## 203 Fore Street Hotel - Preliminary Traffic Comments

Thu, Nov 30, 2017 at 10:39 AM

Hi Caitlin – I have reviewed the application materials and offer the following Preliminary Traffic Comments.

SITE PLAN LEVEL 02 - MIDDLE STREET  
 1/16" = 1'-0"

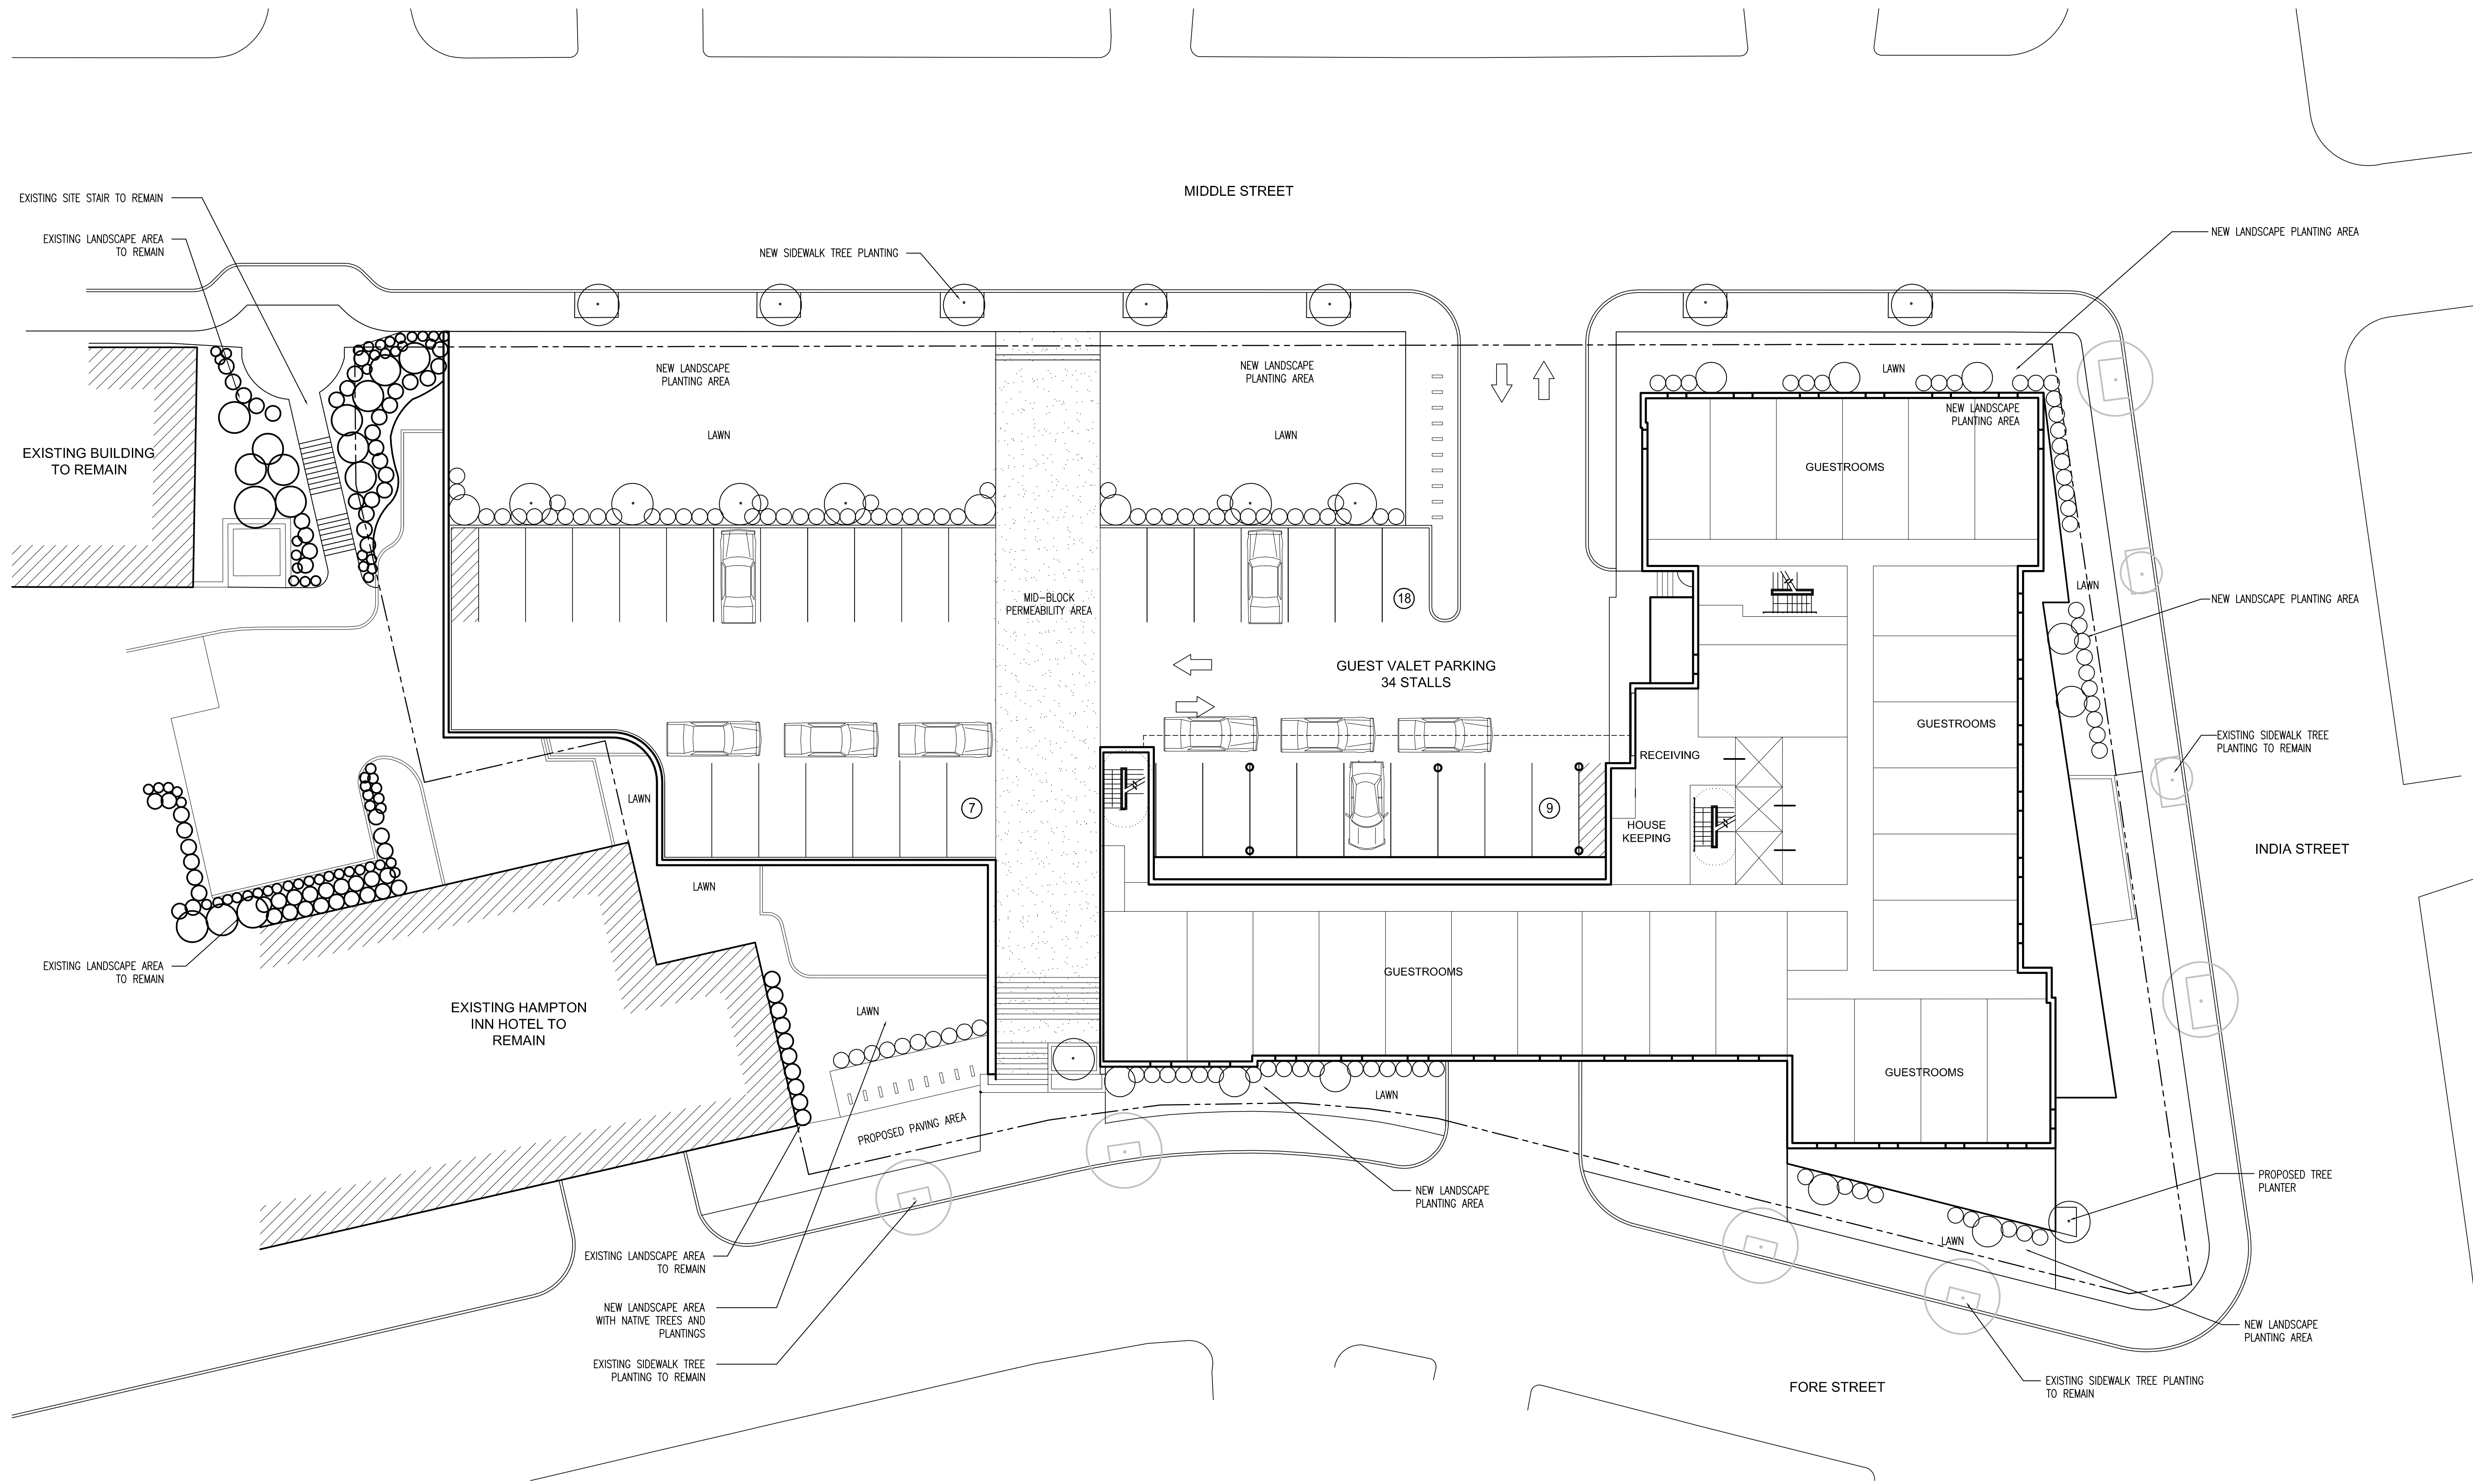
- The project is proposing two driveways (one on Middle Street and one on Fore Street). The number of driveways complies with City Technical standards (assuming the project is NOT a common scheme development. If the Hampton Inn Driveway is considered, the number of driveways exceeds City standards). I would note that the driveways will reduce the number of on-street parking spaces along both streets and thus consideration of narrowing driveway widths may be beneficial.

- I investigated the location of driveways as it relates to corner clearance standards (to India Street). Middle Street is classified as a Local Street and 35 feet of corner clearance is required. The proposed Middle Street driveway meets City standards. Fore Street is classified as a Collector Street and 150 of corner clearance is required. The proposed driveway appears to provide approximately 140 feet of separation and thus either the driveway will need to shift to the west or a waiver will need to be requested.

- The proposed driveway on Fore Street meets City driveway separation standards to the existing Hampton Inn driveway.

- The project will need to provide details on truck deliveries.
- The project will need to provide a parking demand/supply analysis and how parking will be managed between the proposed hotel and Hampton Inn. Also, details on valet parking management and vehicle circulation between to two parking areas shall be provided.
- I will provide comments on parking lot dimensions upon receipt of that information .
- It will be important that the mid-block walkway be designed to optimize pedestrian safety and minimize vehicle conflict.
- A construction management plan that complies with City requirements will be required.
